From: Sue Howell
Sent: 29 January 2019 12:16
To: Planning.Responses
Cc: Andrew Wood
Subject: RE: Planning Consultation on FP/269/18/DOC

APPLICATION NO: FP/269/18/DOC

Site Address: 84 Flansham Lane Felpham PO22 6AH

Description of Works: Approval of details reserved by condition imposed under ref FP/180/17/PL relating to Condition Nos 6, 7, 8 and 12.

DRAWING
**PROPOSED
LANDSCAPE PLAN**

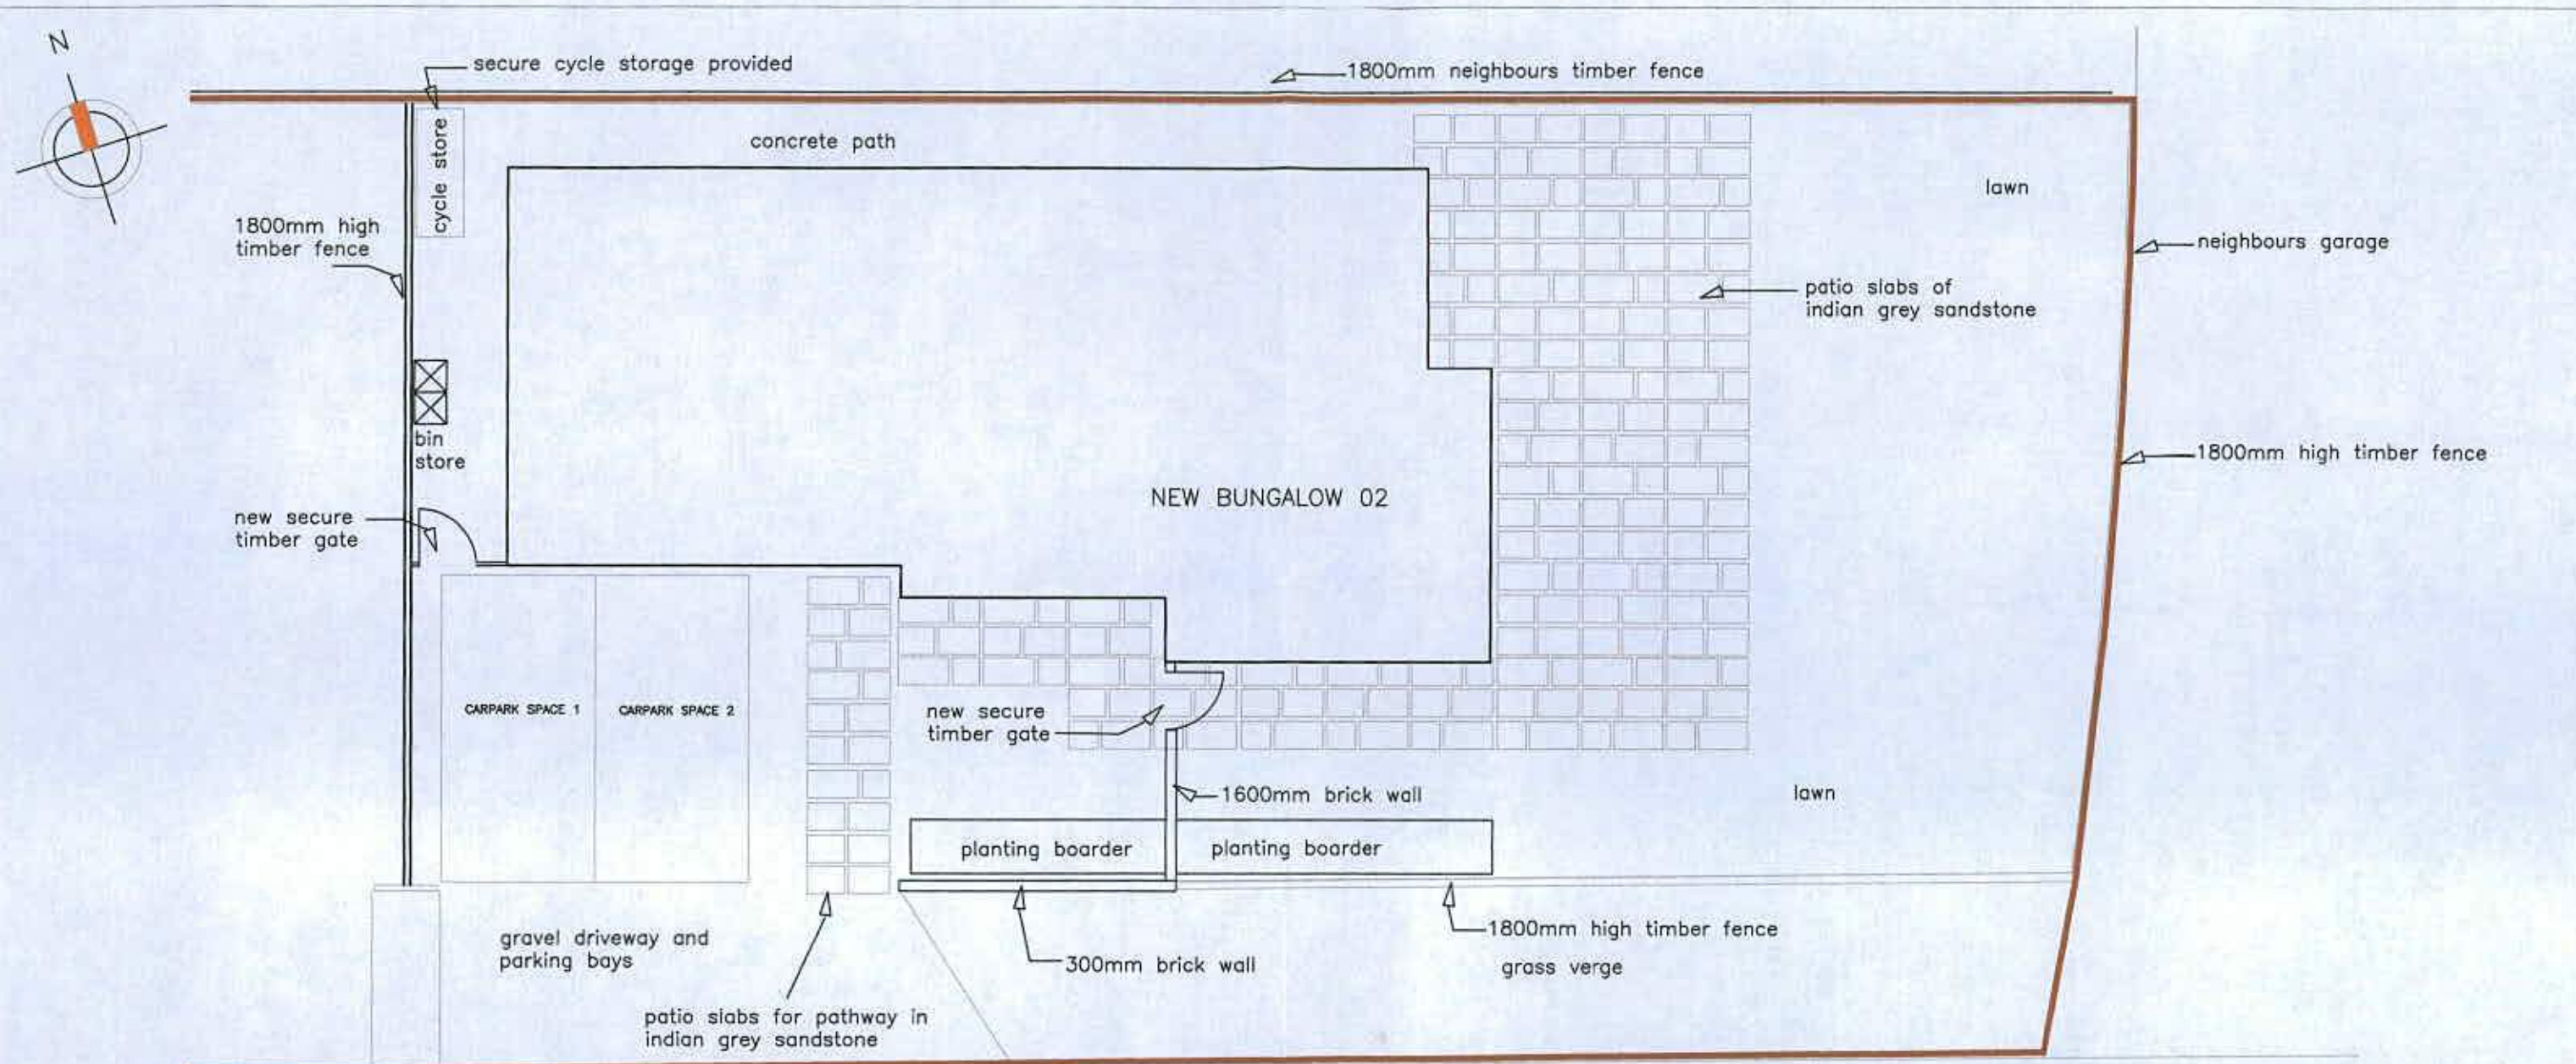
There does not appear to have been submitted a landscape scheme detailed which includes in plan form details of proposed landscaping listing proposed plant choice, actual numbers and size at time of planting. This needs to also show in context any existing trees and planting to be retained. The drawings submitted at present Proposed landscape Plan 232/05 is lacking this detail

I would suggest that there is insufficient information submitted and therefore **would not recommend the discharge of Landscape condition 7** imposed under consent FP/180/17/PL on this application FP/269/18/DOC until this information is submitted.
